AW-344-14-HH – 68 The Drive – extension and swimming pool – 10-2-2015

OBJECTION – AW/344/14/HH – 68 The Drive – extension and swimming pool
within the
Craigweil House Conservation Area and Area of Special Character

Job Title
NORTH & WEST
ELEVATIONS PROPOSED

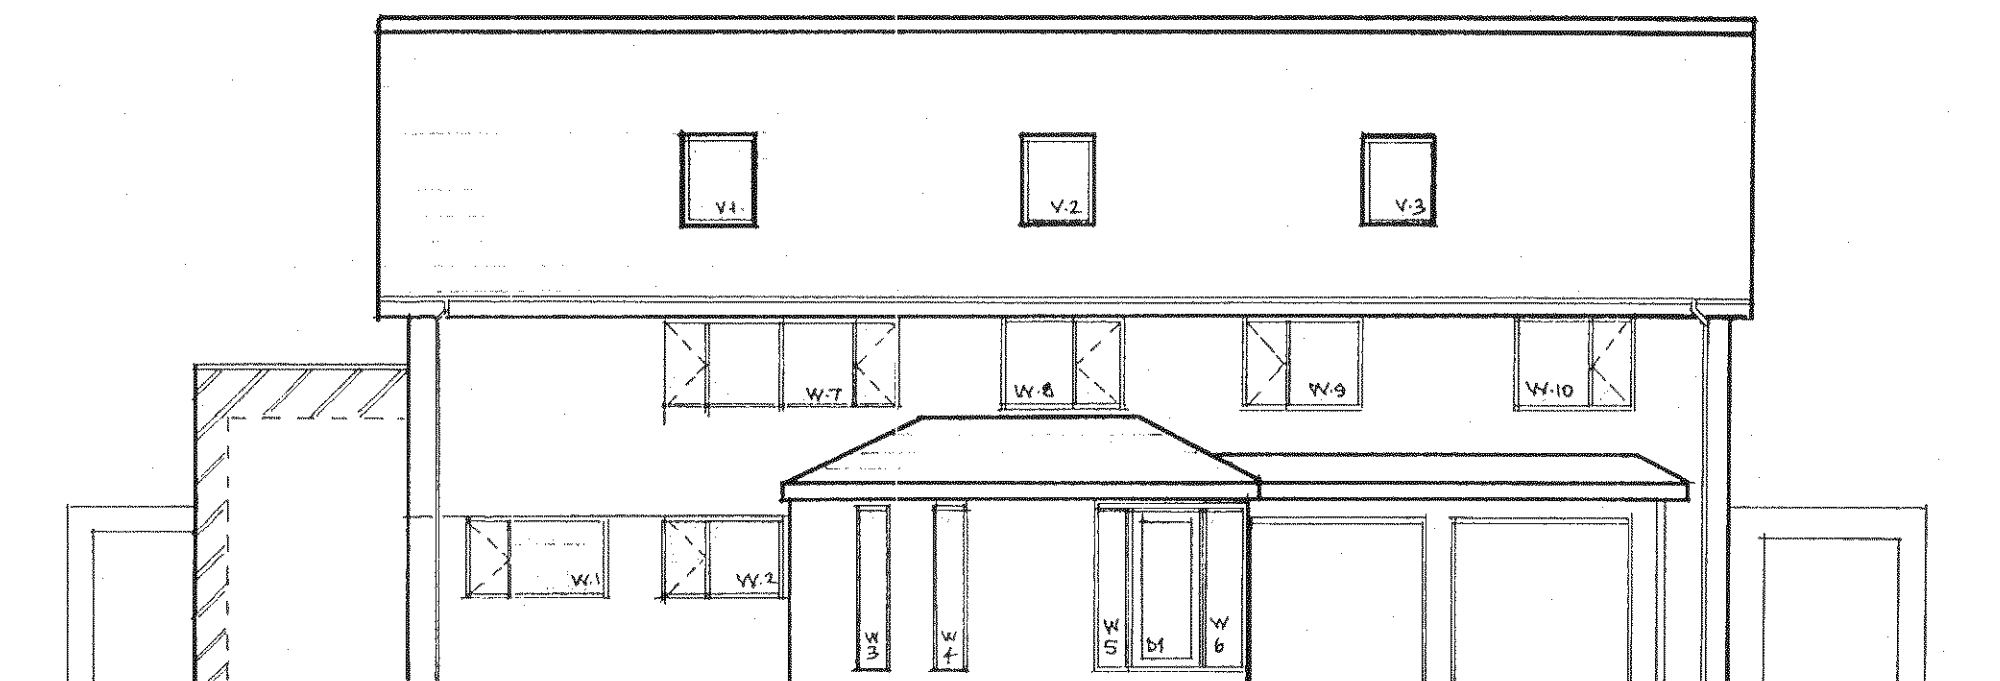
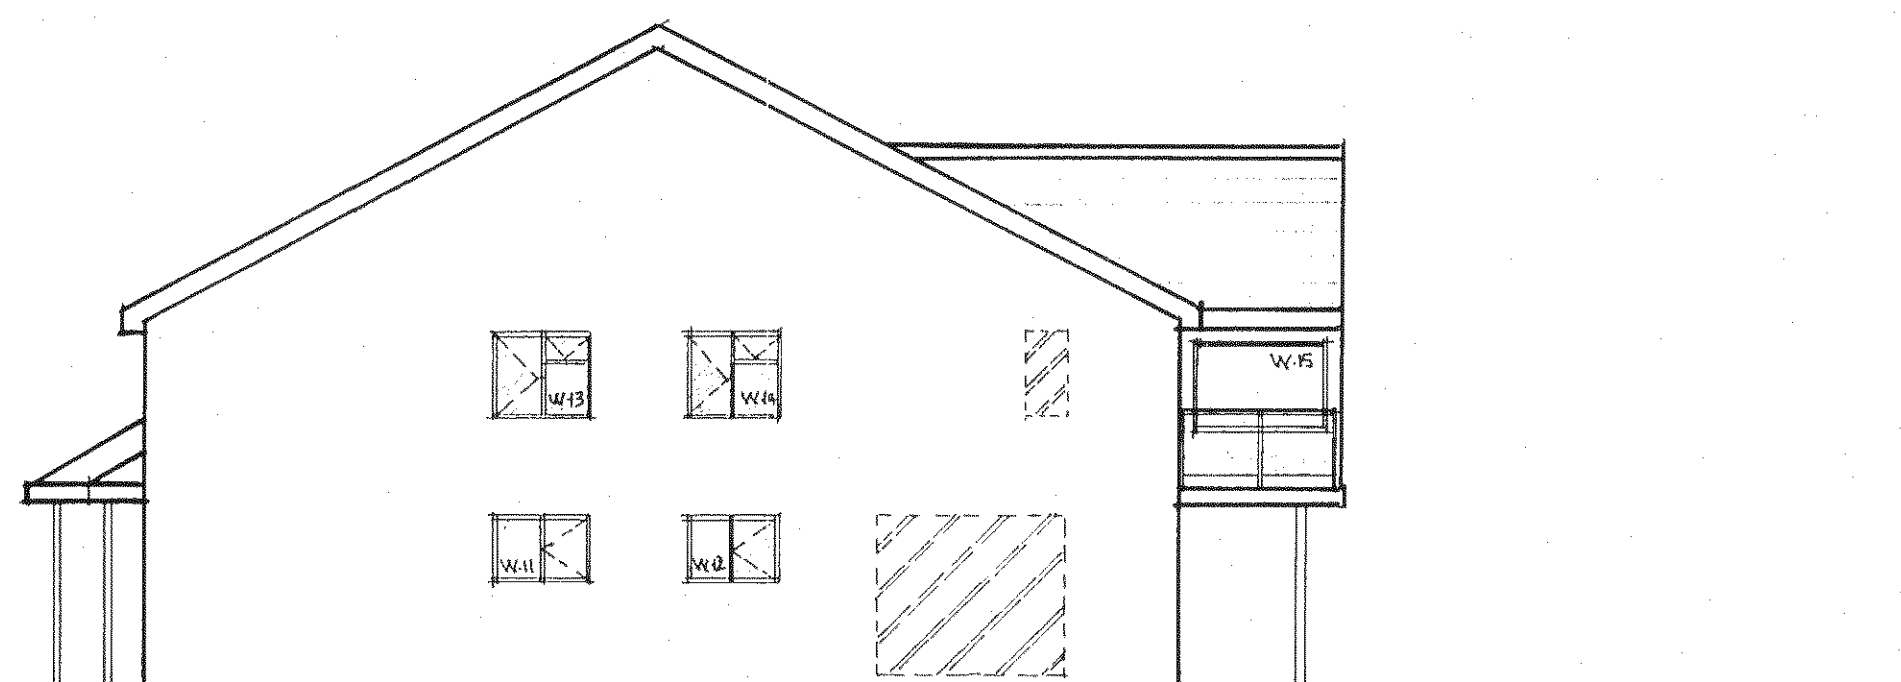
4. CHECAA cannot accept that the change of roof cladding to Welsh (jet black) slate will preserve or enhance or make a positive contribution to anyone except the person selling them. They are an abomination in this location **and we suggest that local Sussex tiling should be used, if it is necessary to change the existing roofing for the proposal is not remotely in keeping with the existing character of the area** and we urge that they are not allowed. The same view is taken of the proposed Marley weatherboarding. **For avoidance of doubt, the Welsh slate at No.72 was erected BEFORE CA designation.**

68 The Drive, Bognor Regis, PO21 4DS

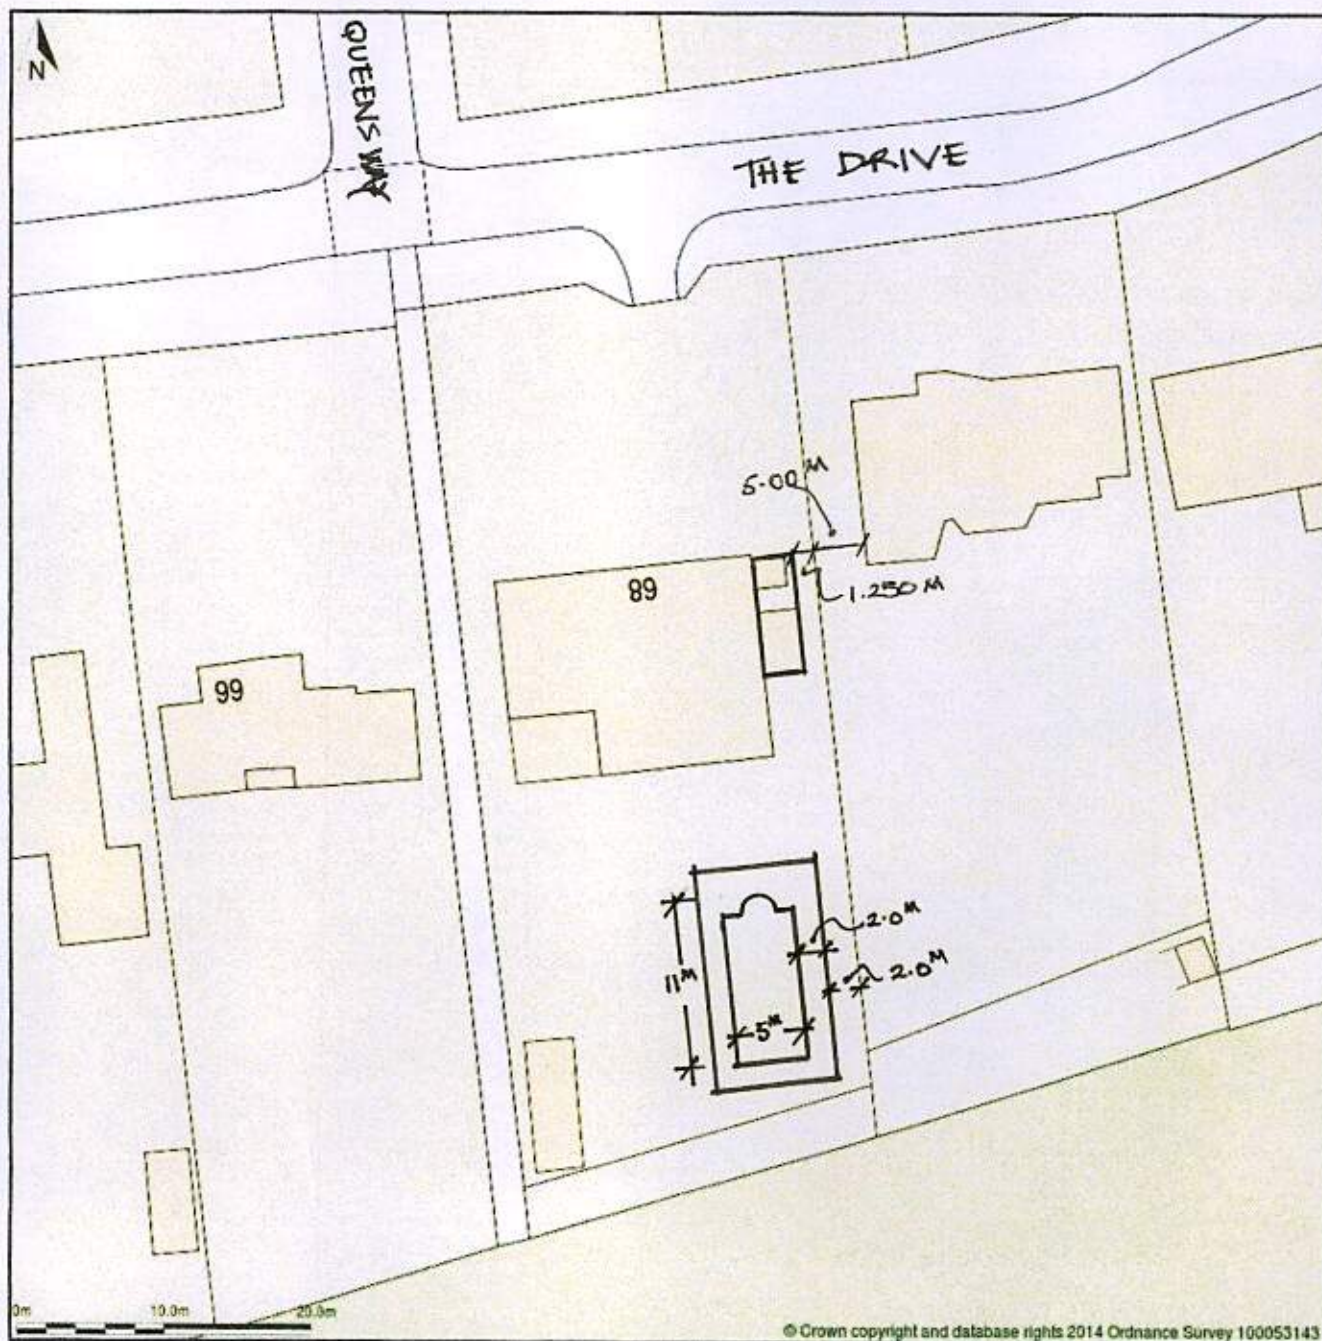
9. CHECAA sees the swimming pool as being totally unacceptable and, located just 2m from the dividing fence with No.70, it can only serve to harm the CA – it certainly will not serve to preserve or enhance the character or appearance or setting of the CA. The pool alone is shown on a block plan only as being 5m x 11m with **no depth disclosed**. It has 2m wide edging which would, normally, be raised with a couple of steps to a level well above existing ground level and it is shown as being 2m from the boundary with No.70 whose privacy will be compromised.

SOUTH & EAST ELEVATIONS
EXISTING & PROPOSED.

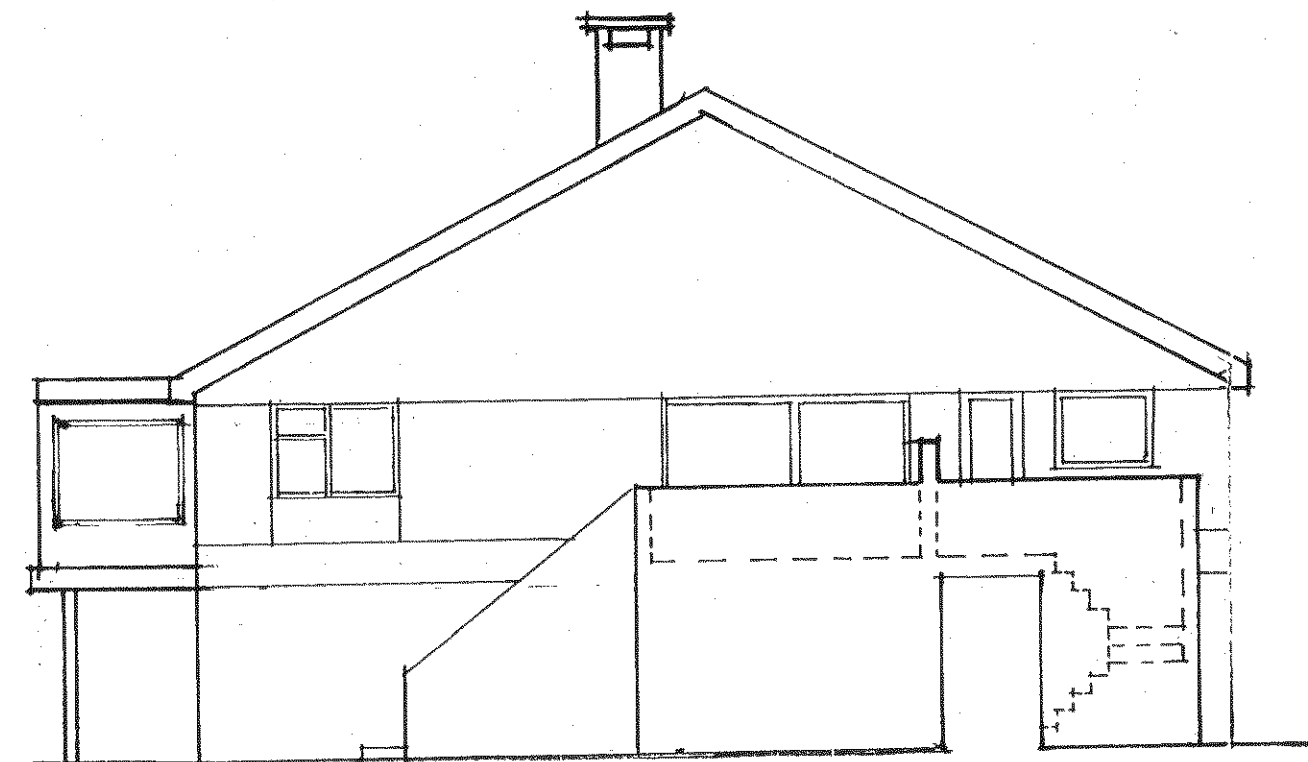
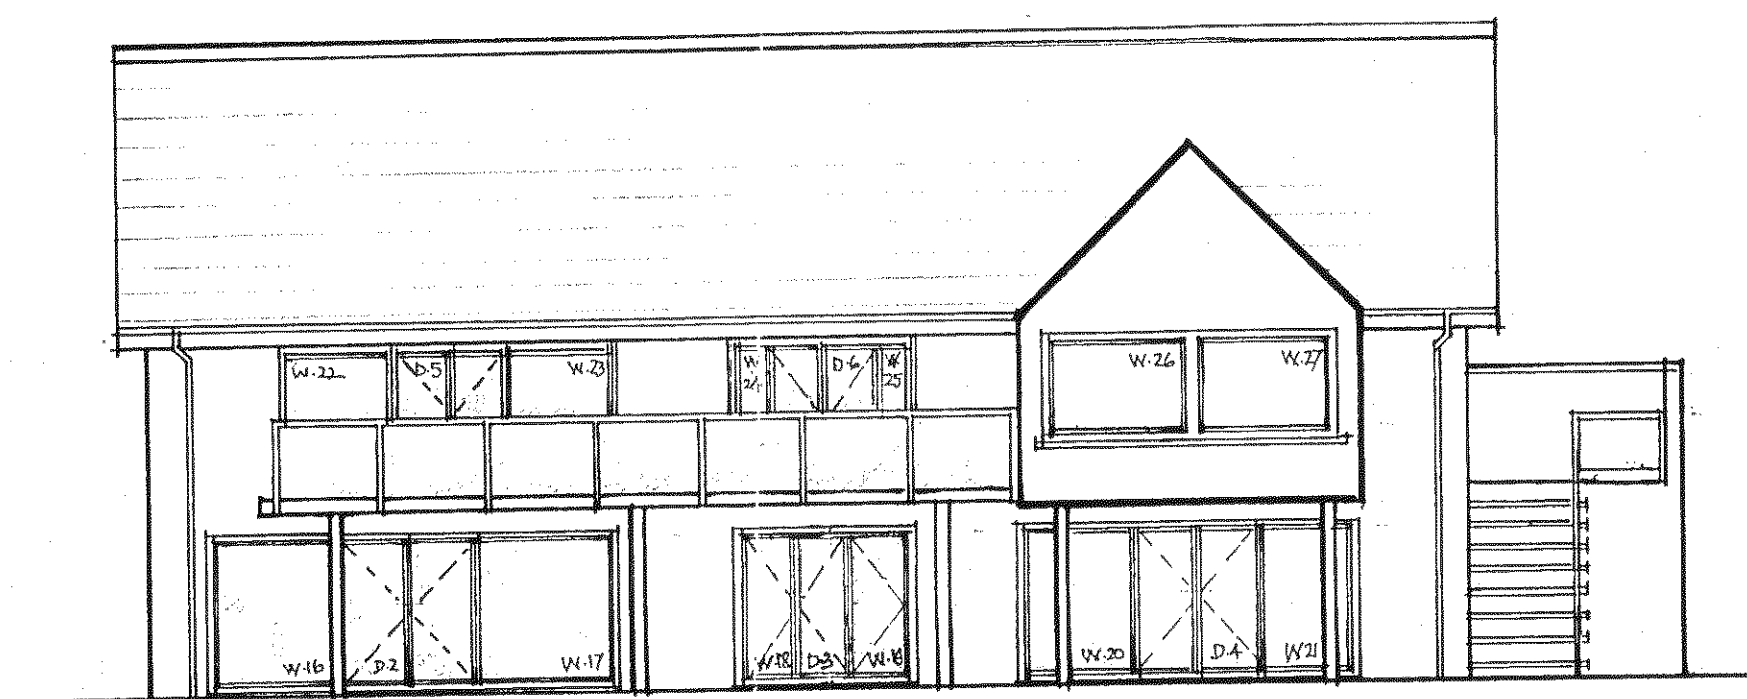
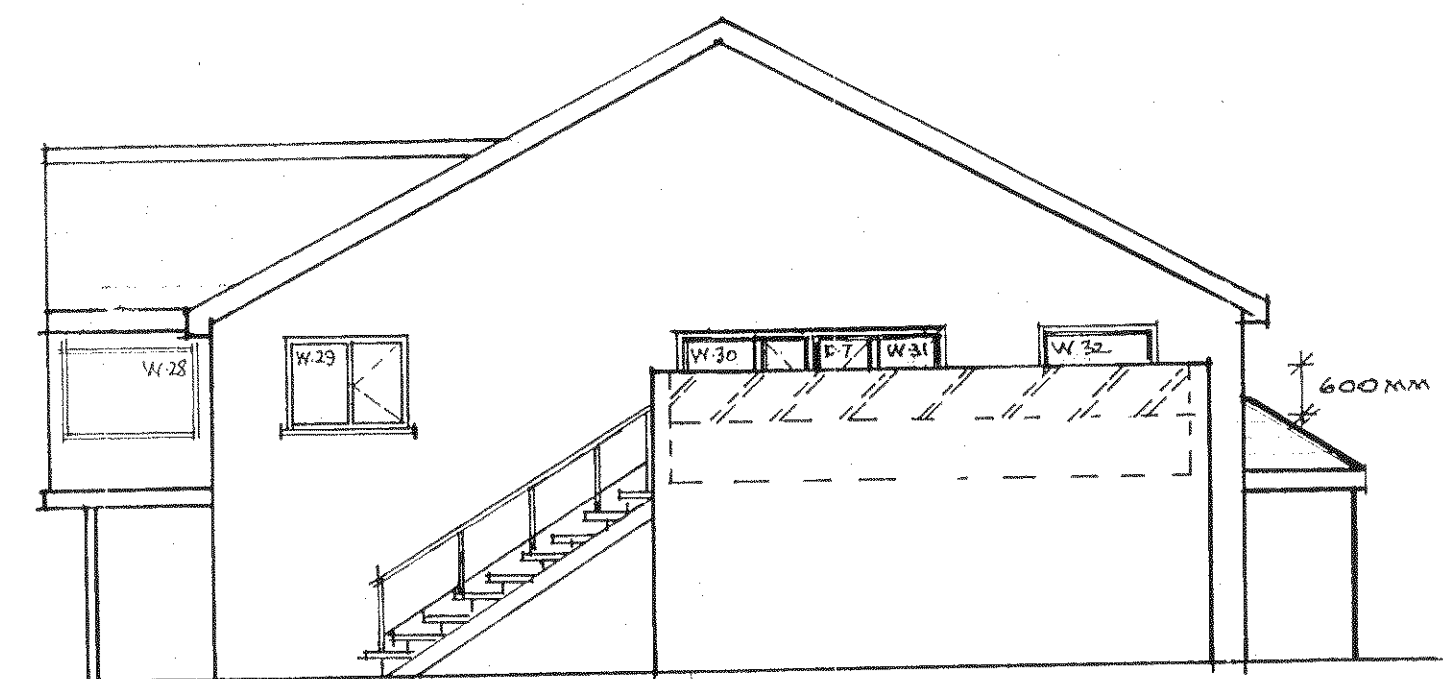
2. Flying in the face of GEN7, again, we say that this development will have an unacceptable adverse impact on adjoining property occupiers on each side. To the east, the proposed ‘terrace’ will, on its eastern edge, align with the boundary with No. 70. It will then have a stainless steel railing with clear glass surround. That terrace will, effectively, sit on top of all who may use the garden of No. 70 and this displays the fact that the applicant has not respected part (v) by taking into account this totally unacceptable adverse impact that may arise. The very concept is unreasonable and needless and selfish for there is ample existing balcony to the rear and south side of this very substantial house. Subsequently, the proposals cannot be seen as making a positive contribution to the quality of the environment as is required by GEN7.

3. Leading on from the intrusive first floor ‘terrace’ proposal, it must be considered within the constraints of Policy DEV19 which states that *‘Planning permission will be granted for extensions to existing residential buildings, provided that:- (iii) the extension does not have an adverse overshadowing, overlooking or overbearing effect on neighbouring properties’*. CHECAA feels that any reasonable person would be hard pressed not to take the view that this ‘terrace’ will be ‘overlooking’ for it does, and, if allowed, always will, facilitate anyone on it – sitting or standing or even coming through the east house door – to overlook No. 70’s house, west windows, terrace and garden. It will also be in conflict with section (v) for the extension will *‘compromise the established spatial character and pattern of the street’ as seen from No. 70, The Drive, the CA, ASC, and SSSI beach to which the public have access. The ‘terrace’ will, in CHECAA’s view, seriously conflict with the provisions of Planning Policy DEV19.*

8. The gable roof which it is proposed should top off the existing massive first floor window appears as an ice cream cornet stuck on top and become an enormous dormer, if effect, and certainly does not comply with GEN7 as '*displaying high quality design*' – it is tawdry and damaging to the property and the CA, causing harm, in our view.

Photo. 'D' –shows No. 68 as seen from the beach, the staircase in the middle which it is proposed to remove, the first floor windows to the right to receive a gable roof, the staircase to the right to be removed and replaced with larger, gaudy steel with glass infill and just fivefold Macrocarpa behind part of which will be the 'terrace' but those trees are past their prime and when gone, that area will be bare and fully overlooked.

Photo. 'E'- view from rear garden of No.70 looking west towards side of No.68 and showing wall of staircase (to be removed and made wide, so close to No.70) where 'terrace' will extend to be in front of windows.
